Application for a non-material amendment following a grant of planning permission.

TWO NEW GARAGES

12/193/10

THE APPROVAL IS FOR ONE GARAGE AT EACH
END OF THE EXISTING BLOCK OF 4.
WE WOULD LIKE TO SITE BOTH NEW GARAGES
AT THE EAST END OF THE BLOCK

Dwg no 9312/1A

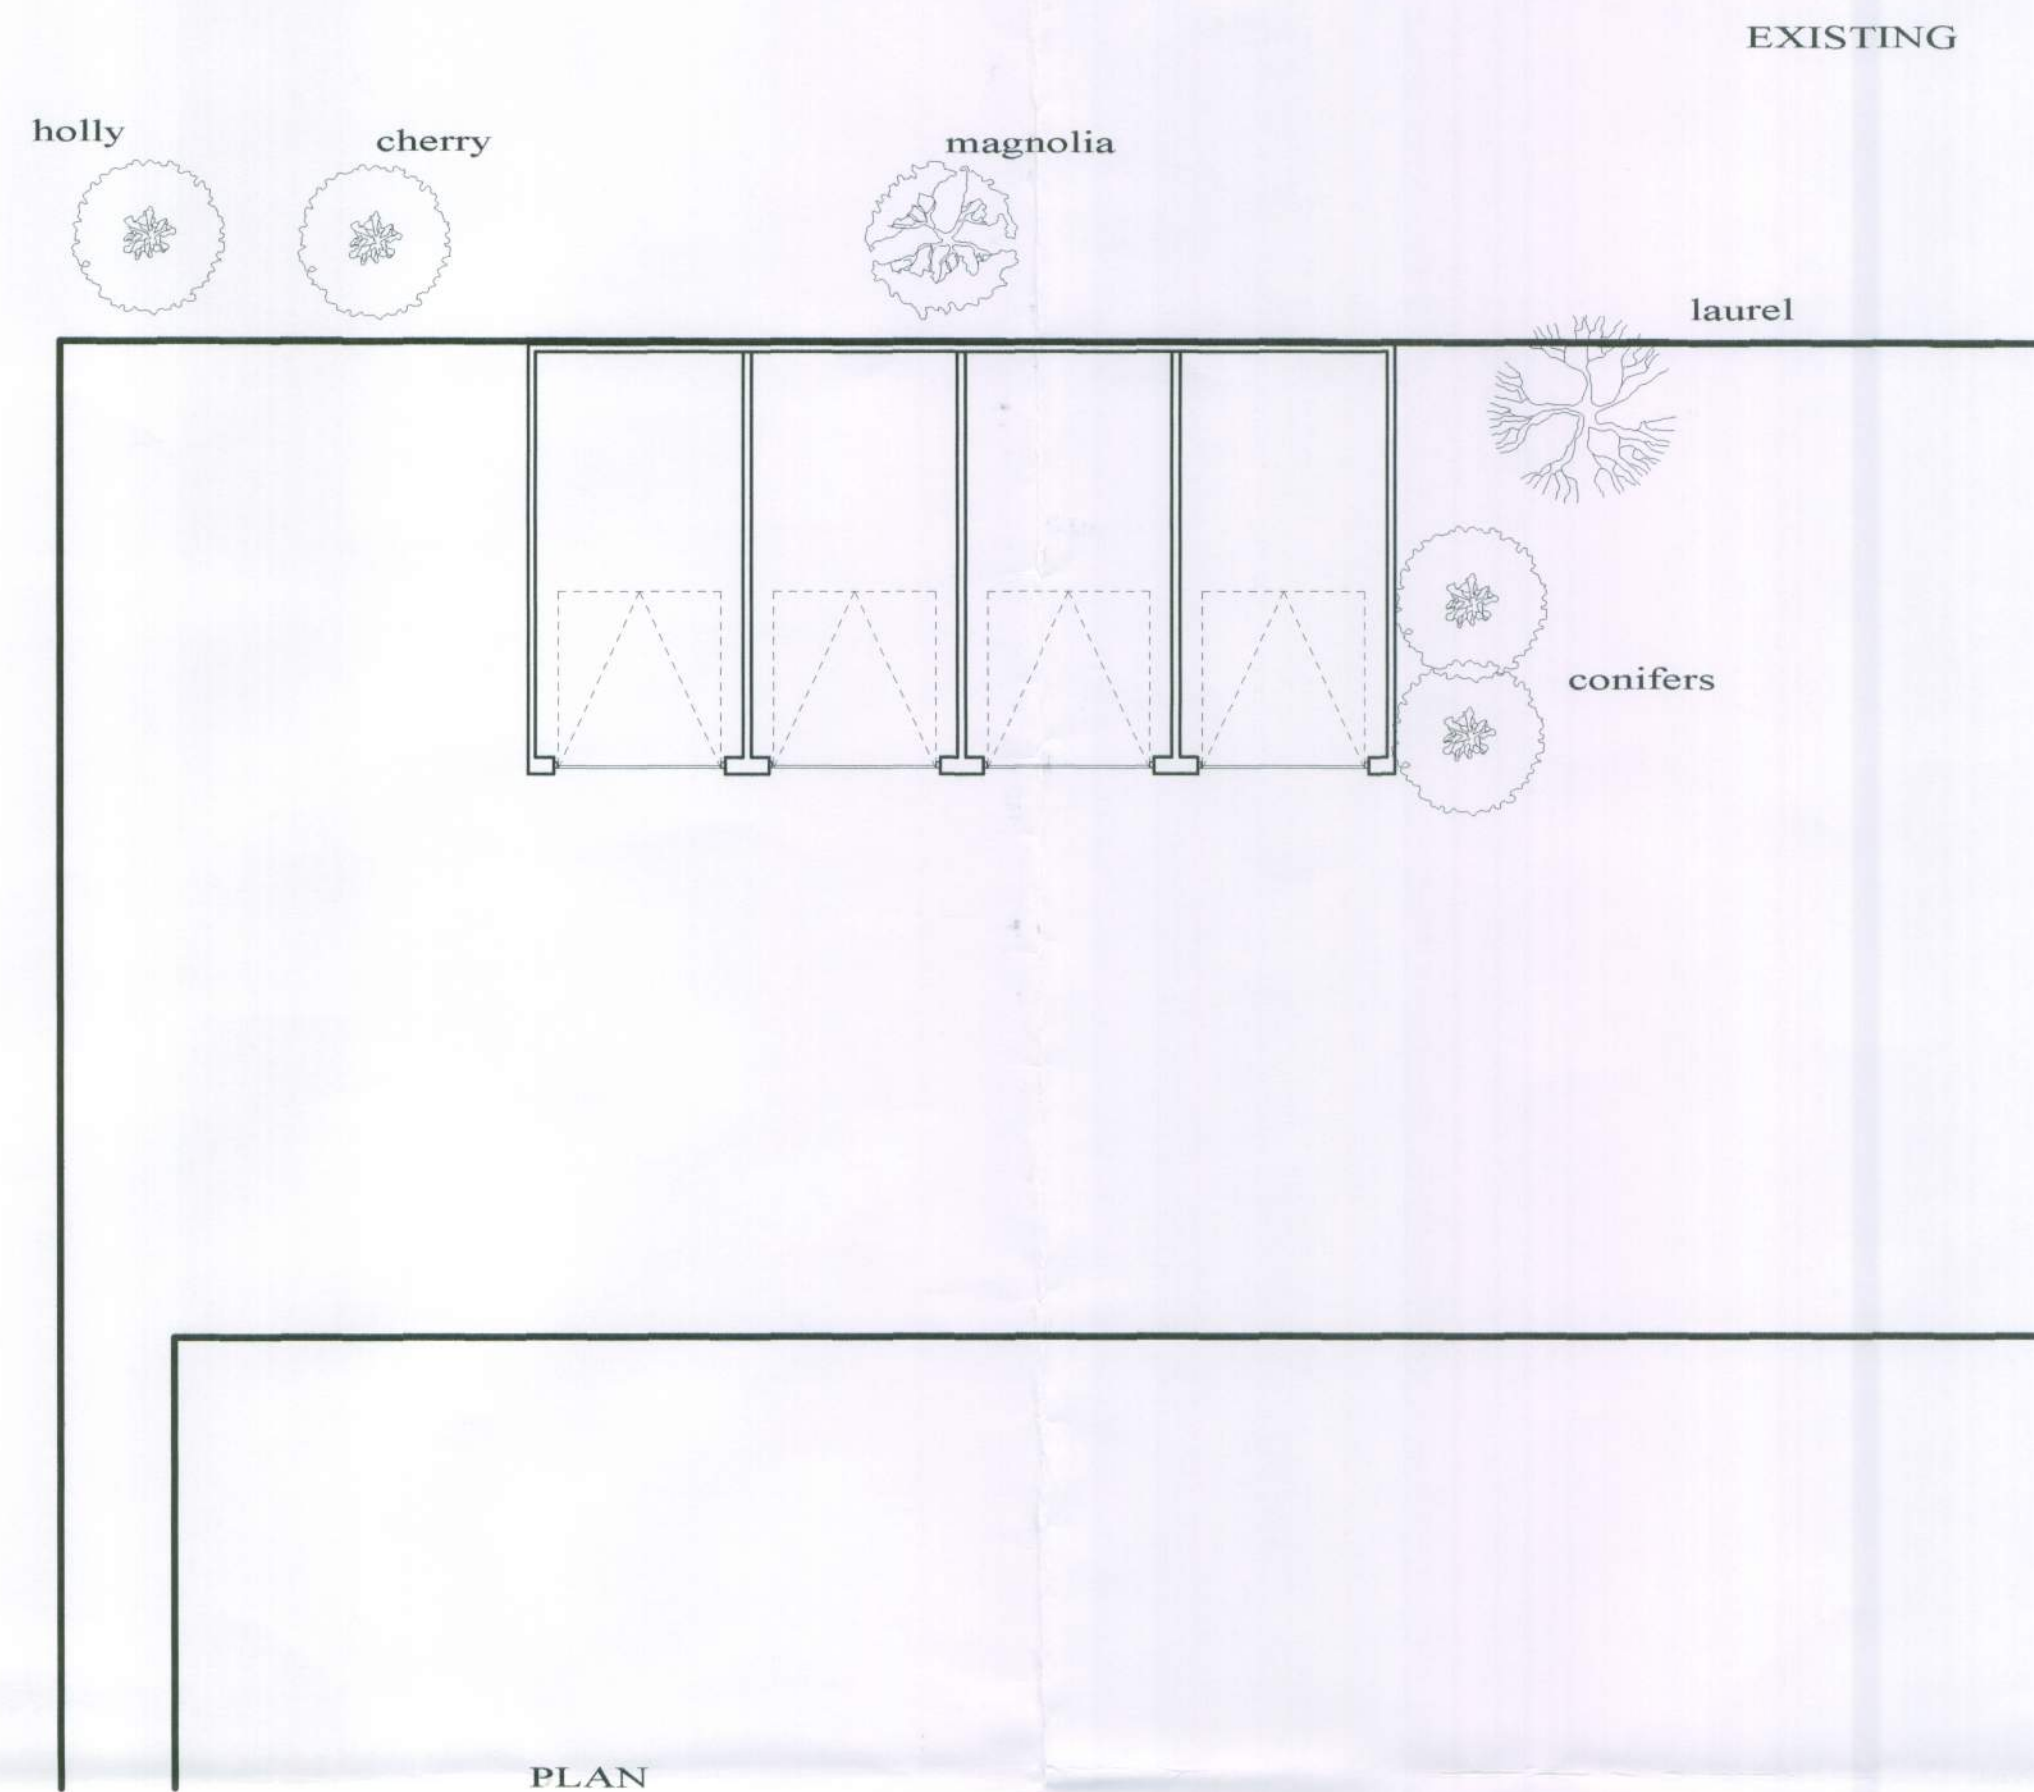
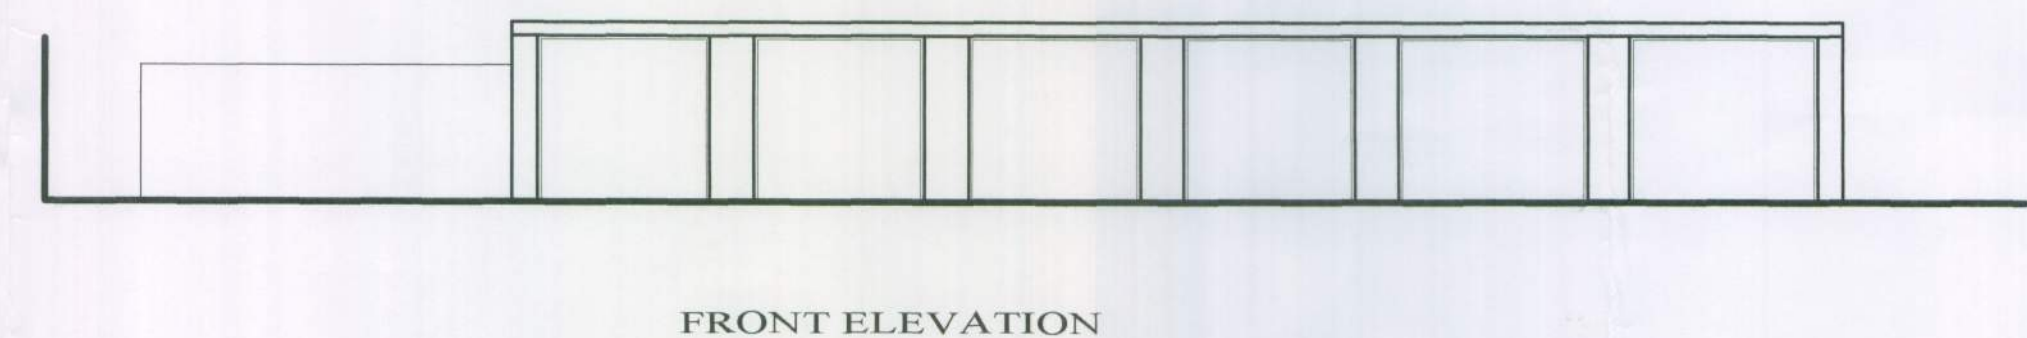
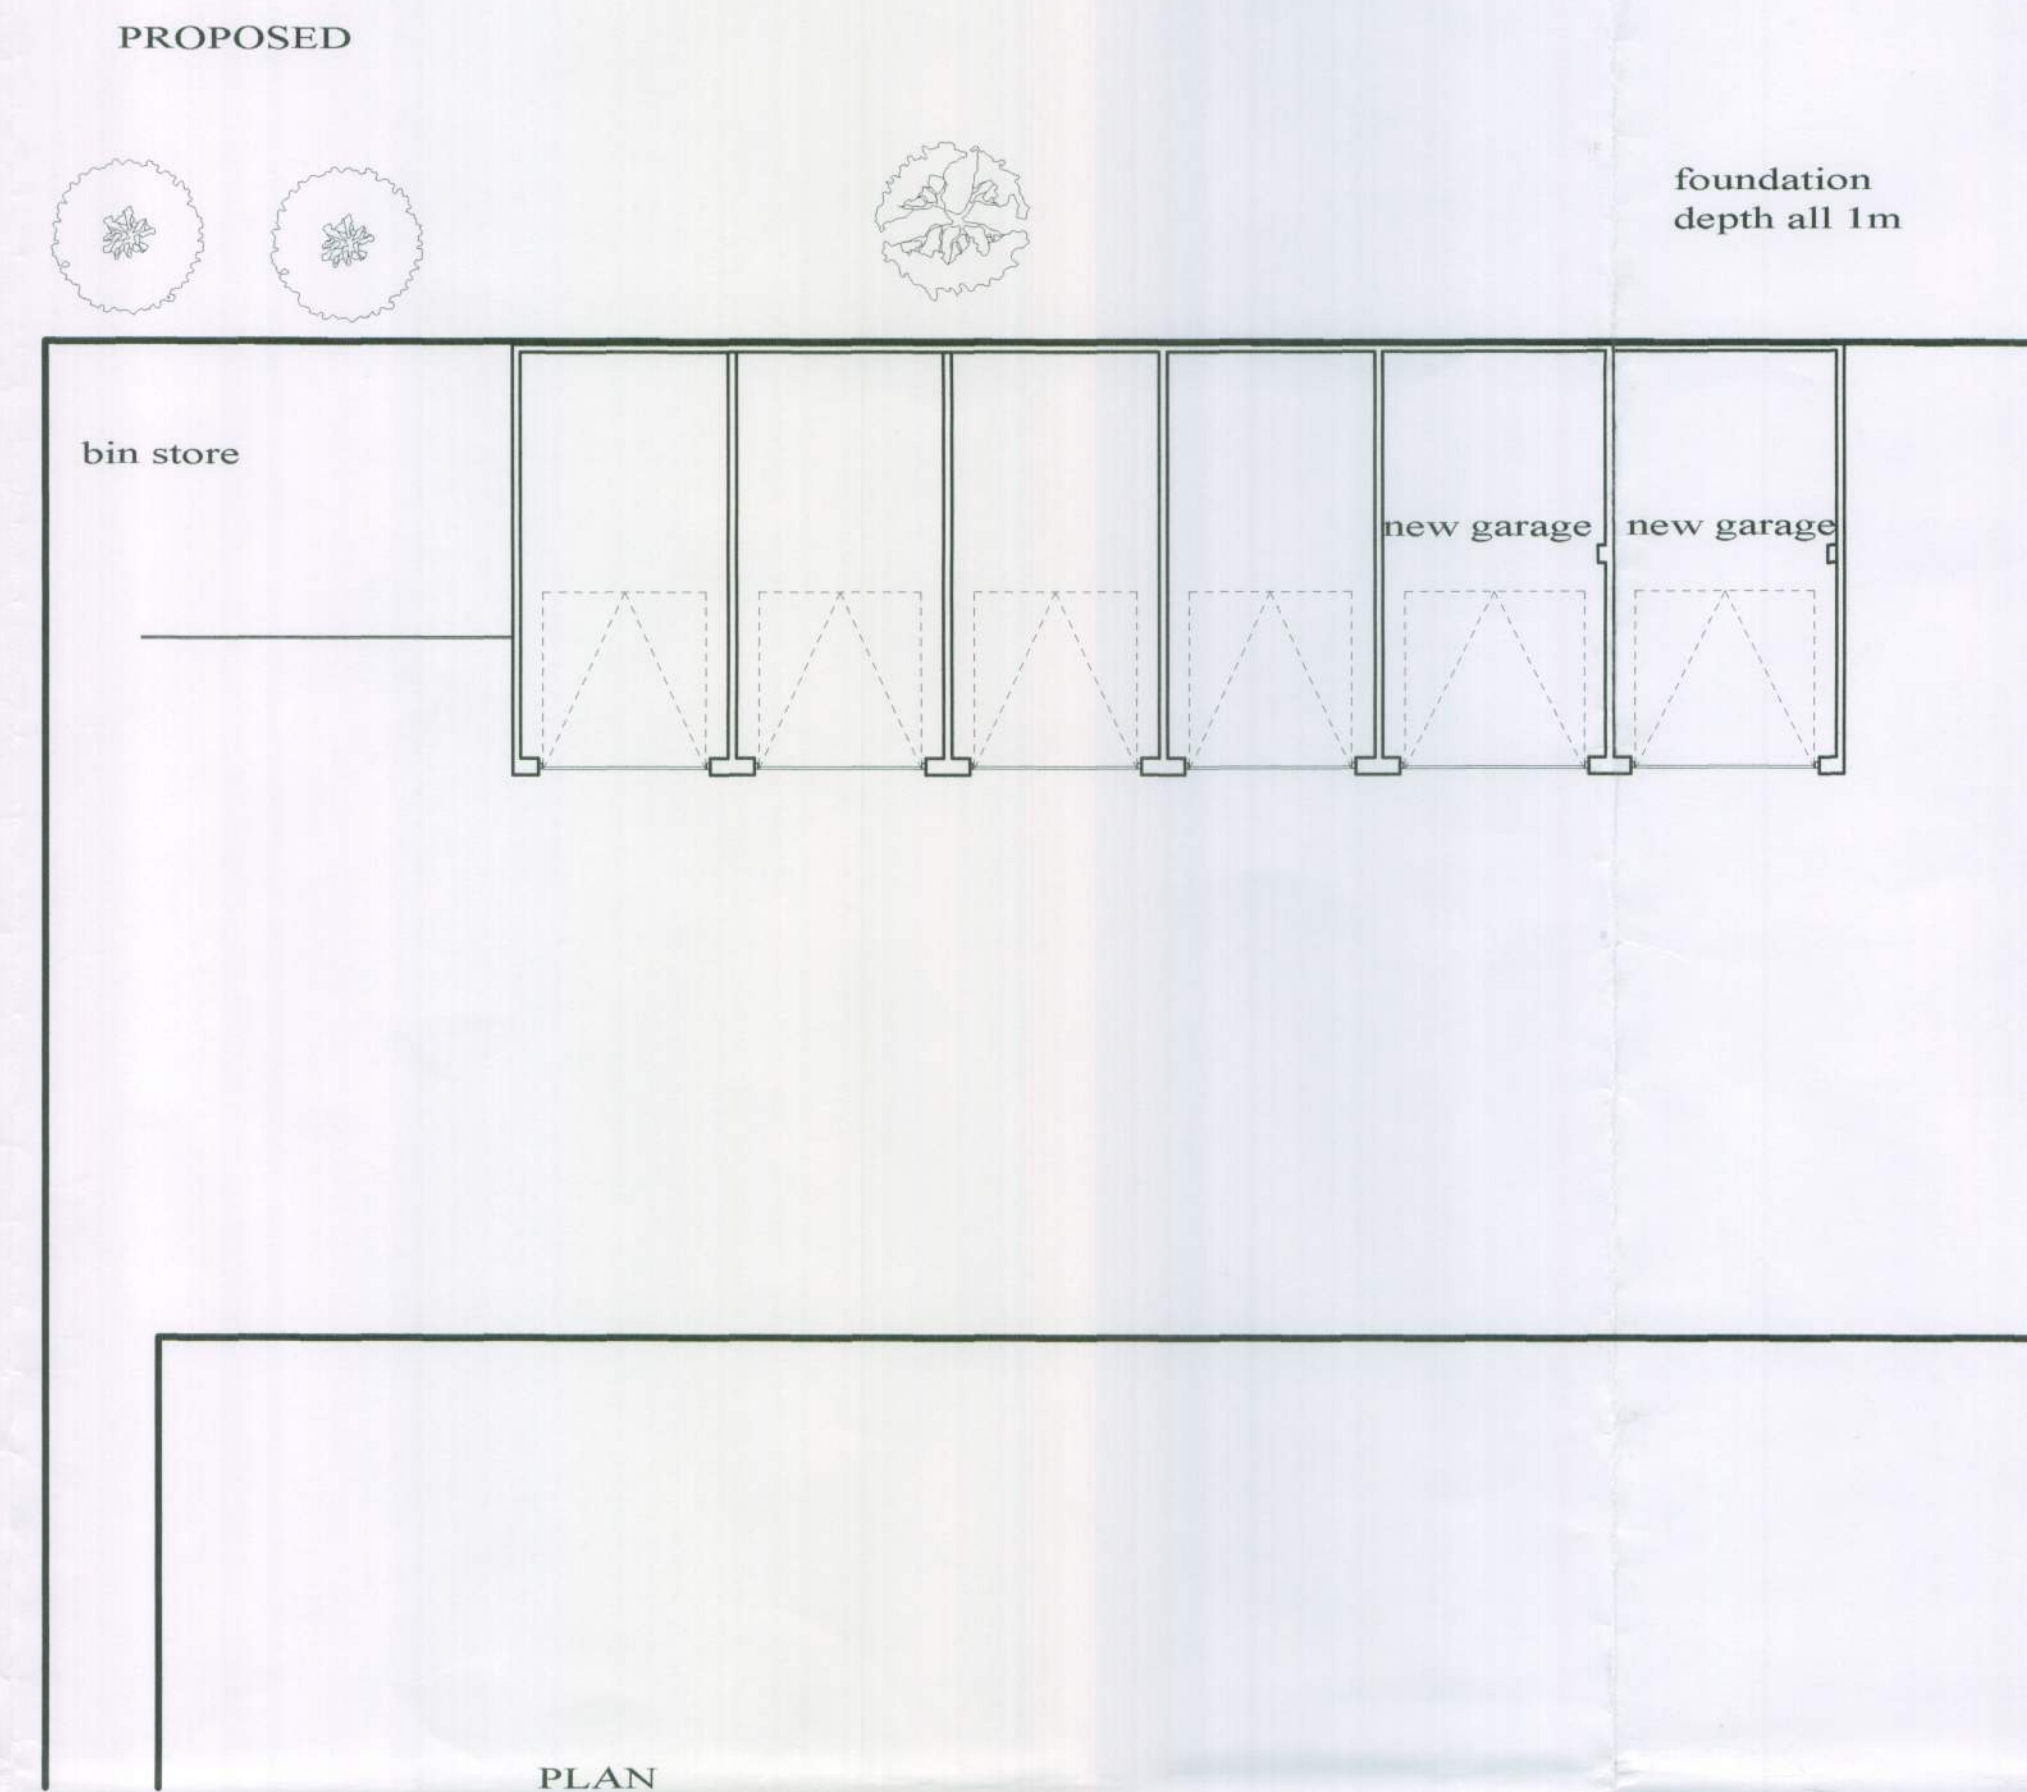
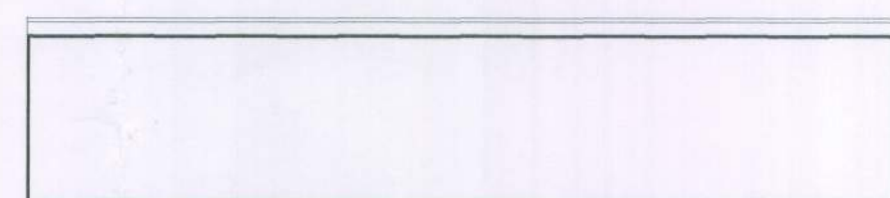
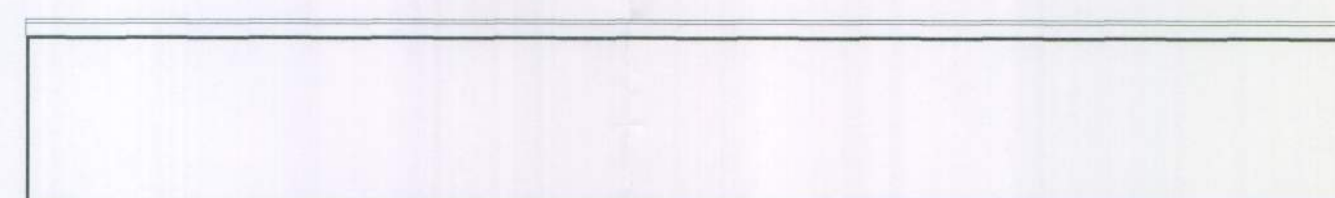
OWING TO ADJACENT TREES THE FOUNDATION DEPTH
REQUIRED FOR THE WEST GARAGE MAKE THE
COST EXCESSIVE

9312/1A
